July 9, 2004

Subject: **Request for Modification to the existing Nationwide 23 and 33 Permit and Neuse River Buffer Certification.** Wake County, Replacement of Bridge No. 273 Over Middle Creek on SR 1006, Federal Aid Project No. BRZ-1006(13), State Project No. 8.2407501, TIP Project No. B-3521. WBS Element 33130.1.1. NCDOT Division 5.

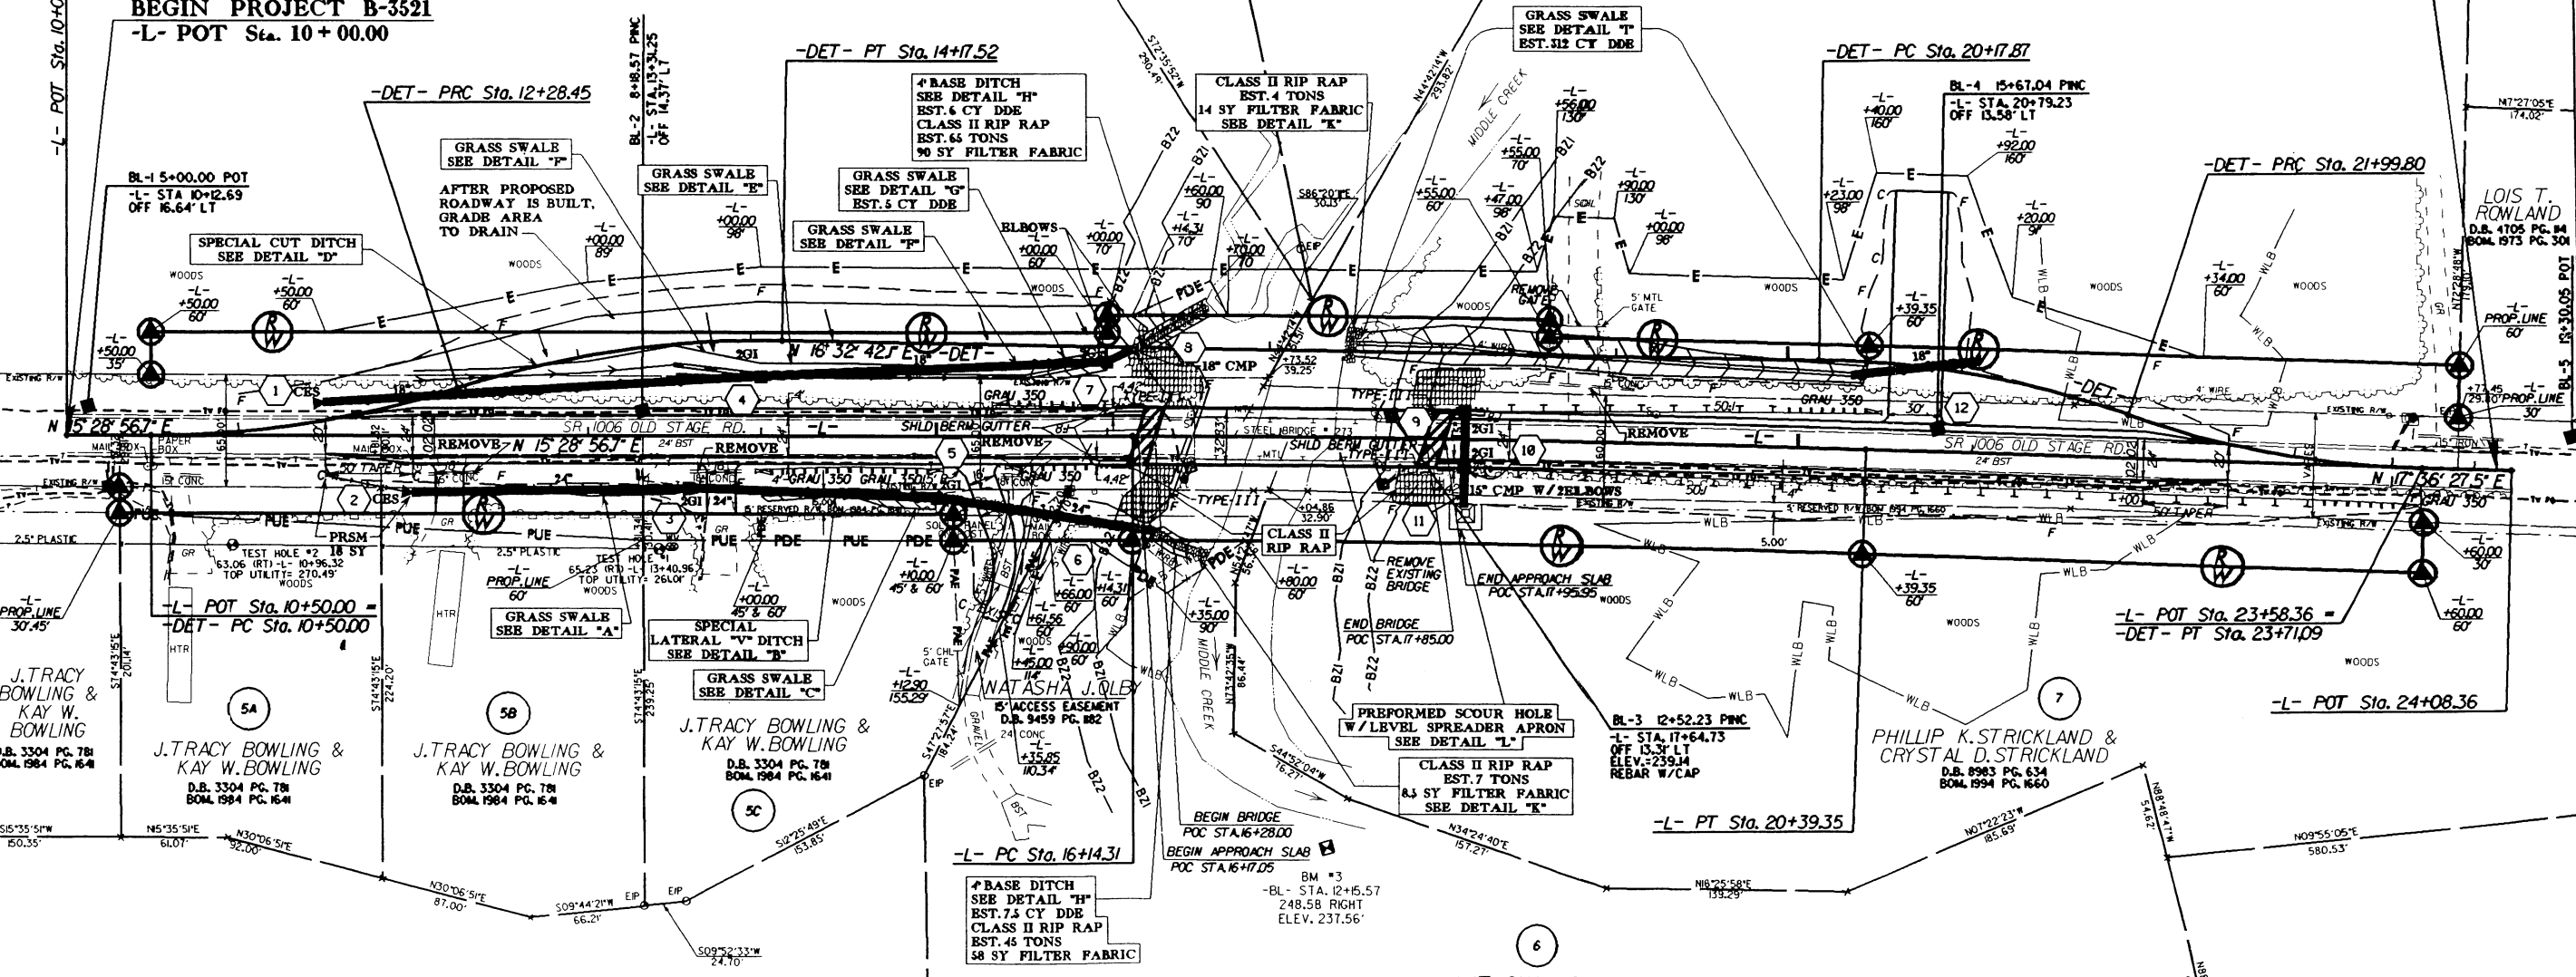
Permit Drawing 4/Plan Sheet 4

- The permit drawing indicates an 18 inch driveway pipe at Station 18+56 Lt. This driveway pipe represents a break in the grassed swale and is not depicted on the plan sheet drawing.
- There is a discrepancy between the permit drawing and plan sheet in the exact footprint of the grassed swale from Station 17+30 to 20+10 Lt.
- The plan sheet indicates an 18 inch driveway pipe at Station 20+50 Lt. This driveway pipe is not depicted on the permit drawing.
- Rip rap lined ditches are located at 16+50 Lt and Rt. The terminal ends of these ditches are located outside of the permitted buffer impacts.
- The buffer impacts associated with the temporary detour are not included on any permit drawing. However, the impacts have been clearly identified on the buffer impact summary sheet.

The permit drawings associated with these issues have been revised and are attached. Impacts at some of the sites have changed based on these revisions:
